RE: DRB Justification Letter for submittal for Final Sign-Off for EPC Approved Site Development Plan for Building Permit – Project Number 1006973

The EPC issued a Notice of Decision on March 11, 2016 to approve Applicant’s application for a Site Development Plan for Building Permit Amendment. The purpose of this Justification Letter is to provide responses as to how the Applicant has addressed the Conditions contained in the Notice of Decision.

LANDSCAPE PLAN
LS-01

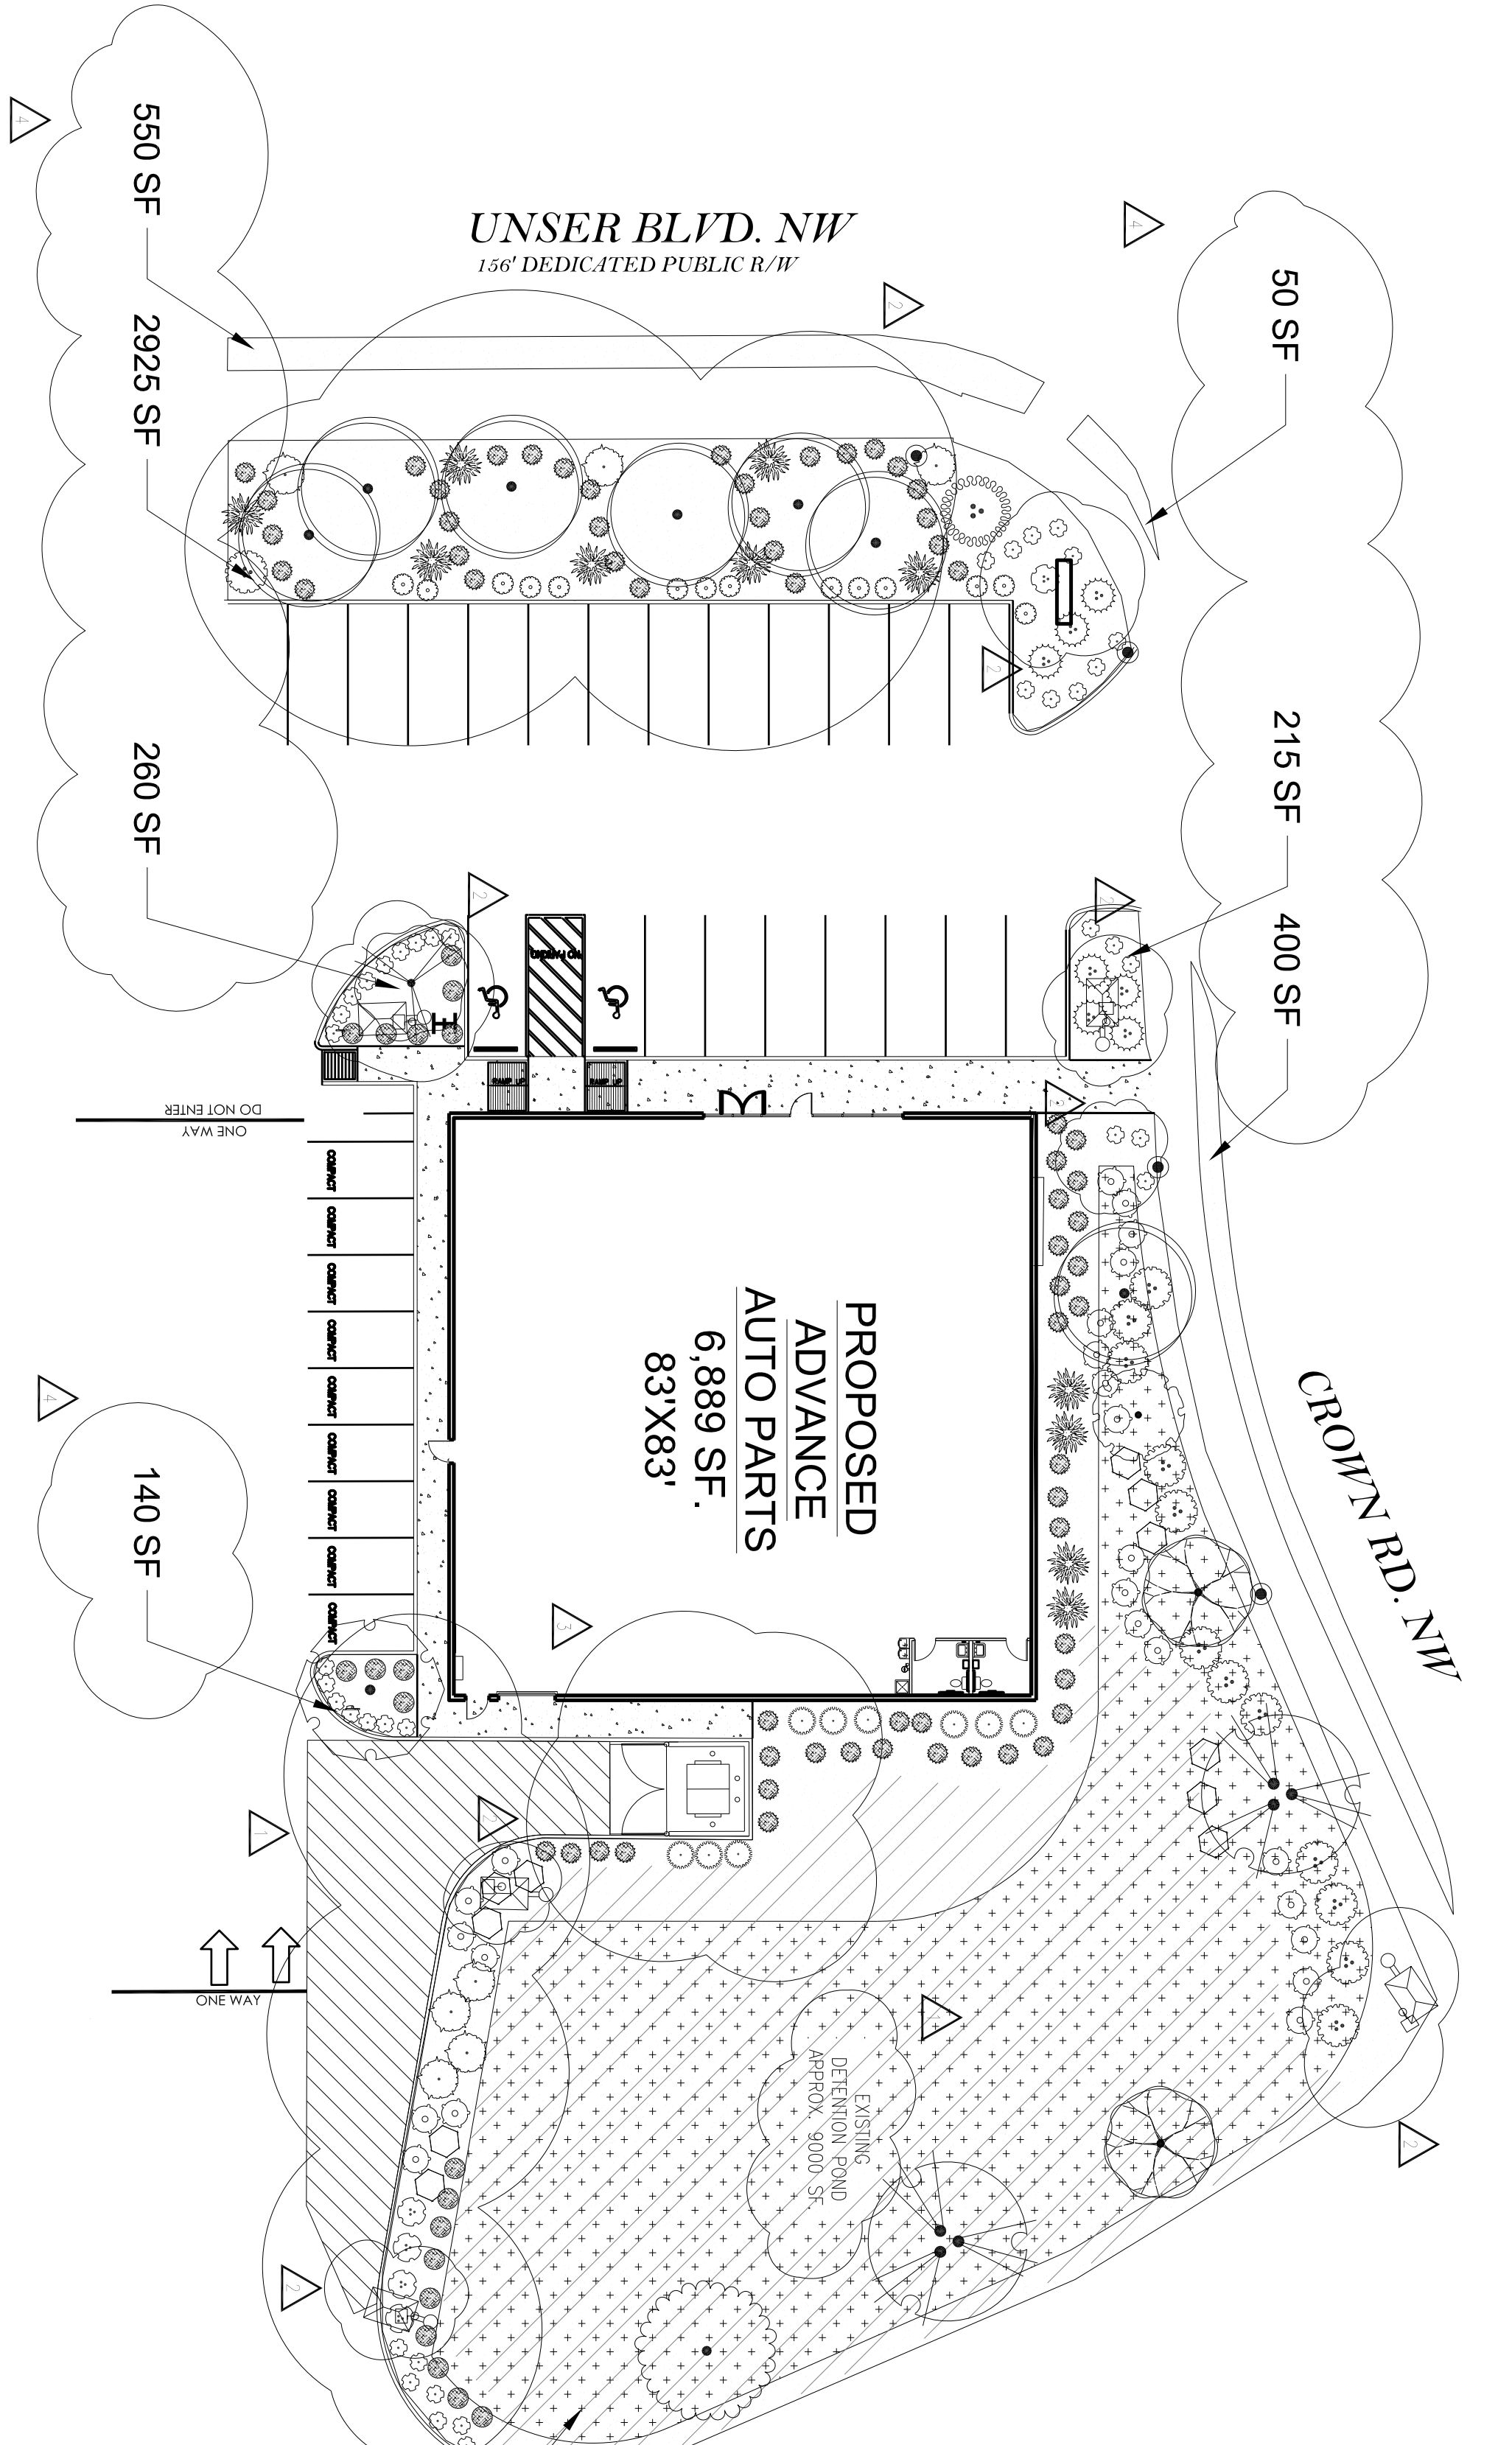
5. The landscaping plan shall show the square footage of each bed so that compliance with the zoning code can be determined.

APPLICANT'S RESPONSE: The landscape plan has been revised to show the square footage of each bed.

**3 SITE LIGHTING DETAILS & SCHEDULE**

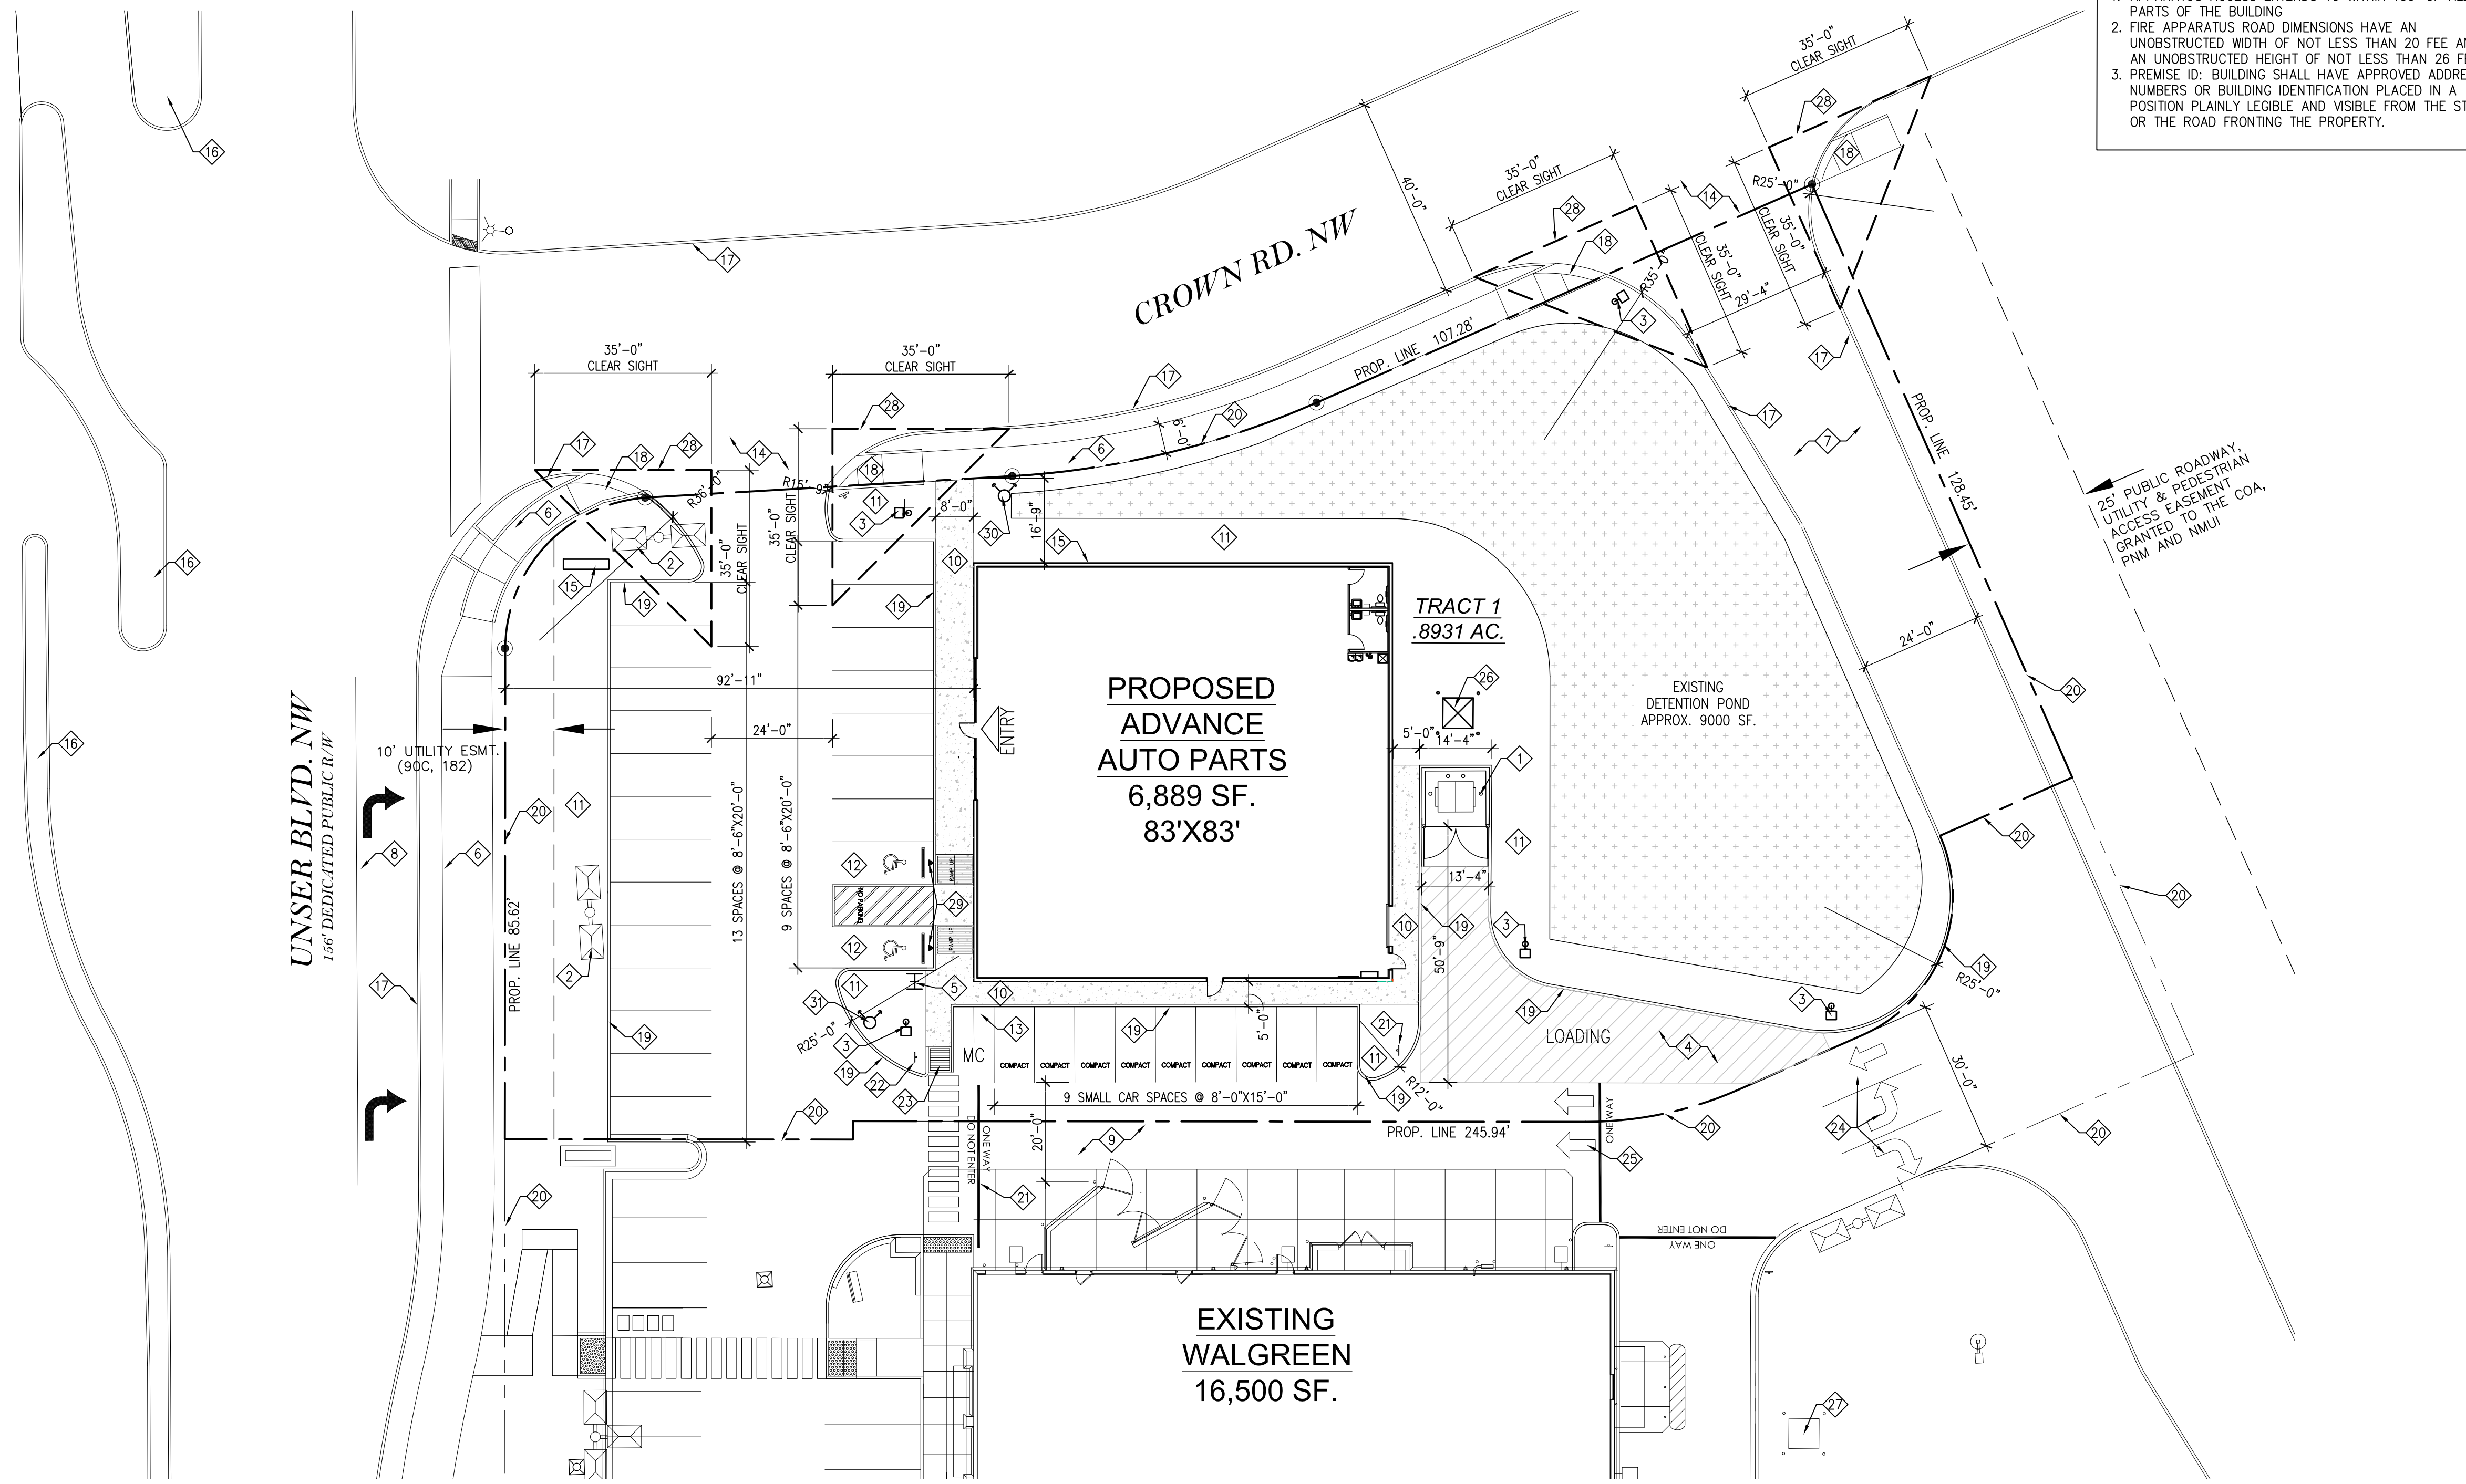
6. Lighting details showing height, type of fixture and location shall be added to the site plan.

APPLICANT'S RESPONSE: The site plan was revised to include a "Luminaire Schedule" with notes added on the type and height of fixtures. The lighting locations are shown on the site plan. See "Site Architectural Key Notes" 2 and 3. Exterior Elevation sheet A6 shows mounting heights of exterior wall scones.
